**Glendenning Road Data Centre (SSD-73761707)**

**Callantha Brigham**  
Director Strategy Design & Delivery

## ATTACHMENT A

Figure 5: Landscape Masterplan of proposed development (Source: GEOSCAPES)

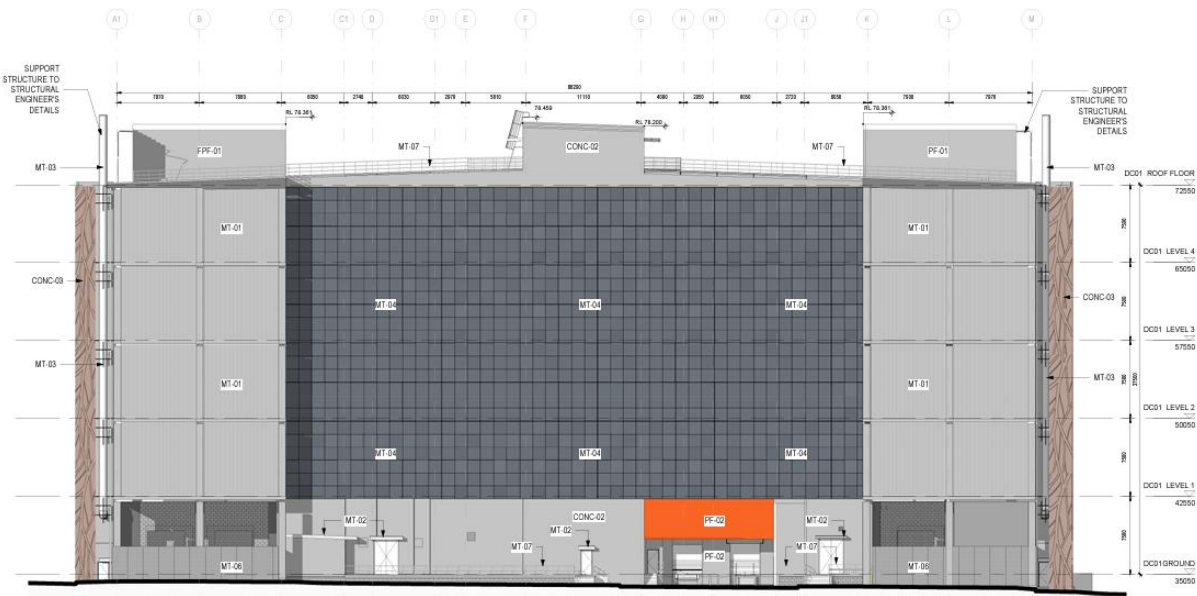
It is recommended that the Landscape Plan is updated to align with species that will enhance the Parklands, extend the Parkland character and soften development impacts, conserve and protect the adjoining environmental conservation area. The attached GSP Species List for Western Sydney Parklands provides alternative species for use in landscaping for the proposal, particularly the 'CPW and Shale Gravel' species list (first tab in the attached Excel sheet). Specific recommendations are:

- Replace the proposed evergreen screening species with Cumberland Plain Woodland species that are suitable for screening such as *Exocarpus* or *Melaleuca* sp.

- Amend the planting schedule to
  - remove species that are not Cumberland Plain Woodland species including *Melaleuca armillaris*, *Lissanthe strigose*, *Pimelia curviflora* var. *curviflora* and *Austrostipa setacea* (the latter could be replaced with *Austrostipa ramosissima*).

- Reduce quantity or remove *Lomandra longifolia* and *Dianella longifolia* as these species are not dominant Cumberland Plain Woodland species.
  - Remove the following species that become invasive

- *Pennisetum alopecuroides* proposed as part of the swale planting. This could be replaced by *Carex appressa*
    - *Cupaniopsis anacardioides*
- Consider removing *Syncarpia glomulifera* as it's unlikely to grow true to form in this area due to the heavy clay soils

- Reconsider the species proposed for the planting beds within the development and on the western boundary to be in keeping with the remainder of site landscaping, preferably using species from the Cumberland Plain Woodland species list.

Figure 5. Site Catchment and Overland Flow Path Plan

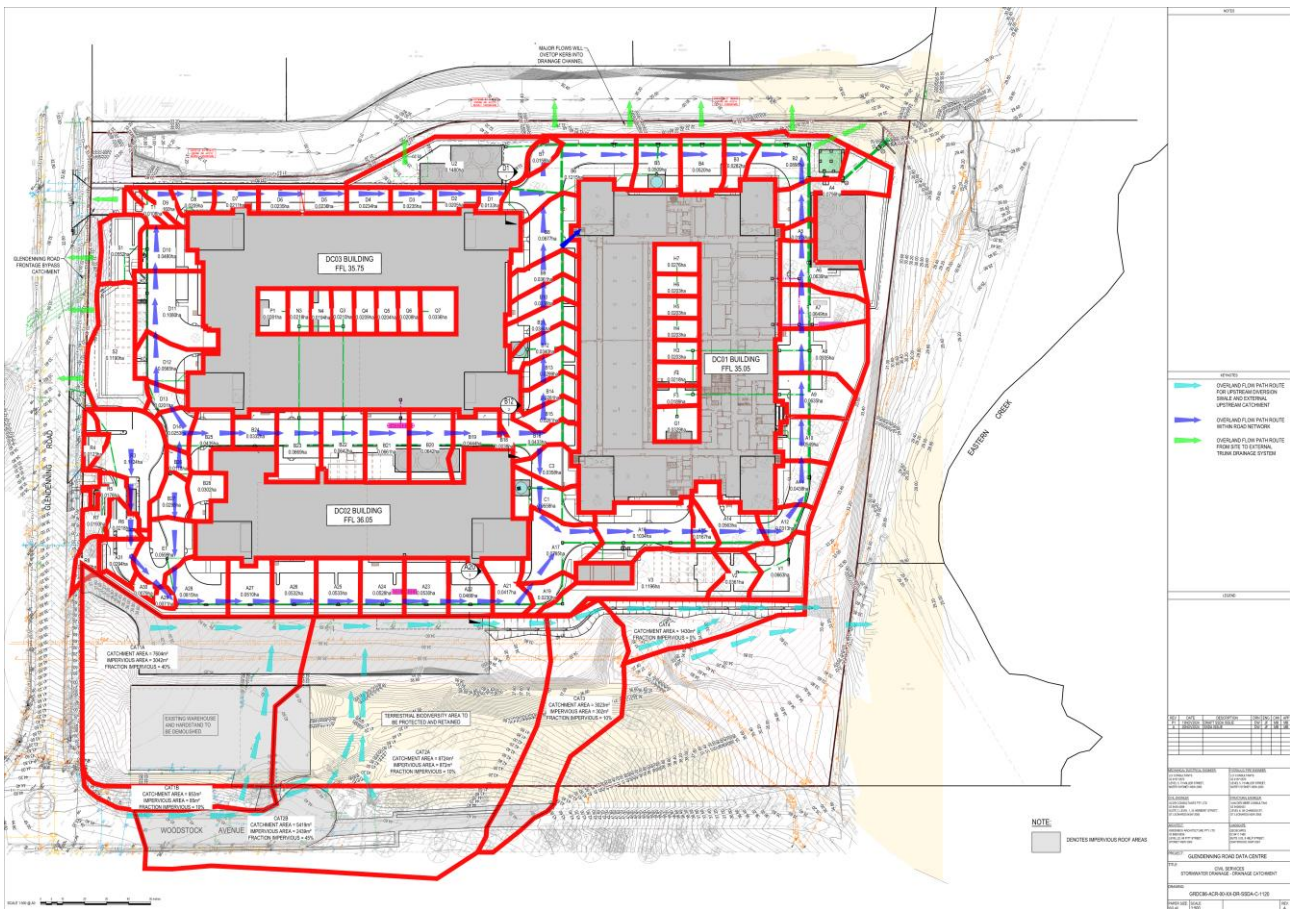
While the site is in a location that is exempt from stormwater detention under Council's controls, further information is requested on the existing and future quantity and quality of overland flow to avoid impacts on Western Sydney Parklands.
